NorthConnex Application Number: SSI 13_6136

Please find below my submission in response to the exhibition of the EIS for NorthConnex.

NorthConnex EIS Submission

MOTORWAY OPERATIONS COMPLEX - SOUTHERN VENTILATION FACILITY - SECTIONS
M1-M2-5000-DR-JD-0525

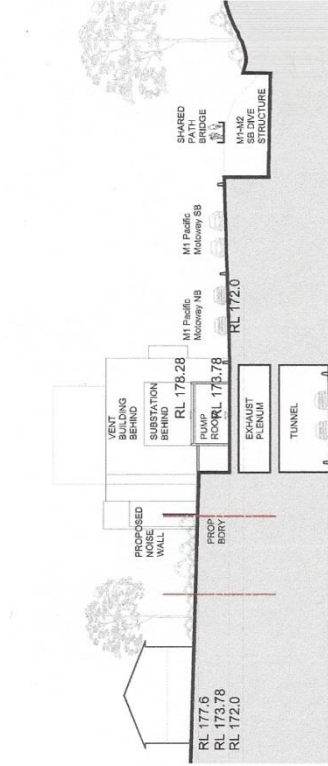
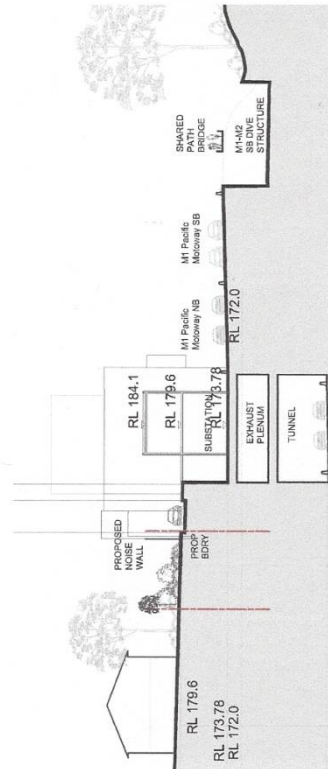
2. that the southern portal and exhaust stack site have been located with insufficient consideration for the amenity of surrounding homes. The water treatment plant, substation and switch station (located on adjoining Coral Tree Drive) are not proposed to sit above the portal, as on the northern portal but are still proposed to be above ground level. While a noise wall appears to be proposed to separate only part of the site from adjoining homes there has been no attempt to minimize visual impact on these homes. Extending the noise walls along workshop storage areas and other areas subject to site traffic and maintaining the height of the treatment plant, substation and switch station below the noise wall, by constructing them as necessary below ground level would appear an easy way to minimize the visual and noise impact on community amenity. Effective vegetation screening around service yards, storage areas and workshops appears on NorthConnex publications and should be mandated by Department of Planning and Environment to minimize visual impact to surrounding homes.

3. that the operating noise of the pumps, substation, jet fans within the tunnel and exhaust fans within the stack will have a significant and intrusive acoustic impact on homes located close to the exhaust stacks. While at the northern portal the portal and the substation and pump room located above it, will be behind a sound wall, the height of the equipment will locate it up to 10 metres above the top of that wall. Should an attempt be made to increase the escape velocity of the pollution being emitted from the exhaust stack, in an attempt to increase mixing and dispersal, this is likely to result in higher fan and air flow noise.
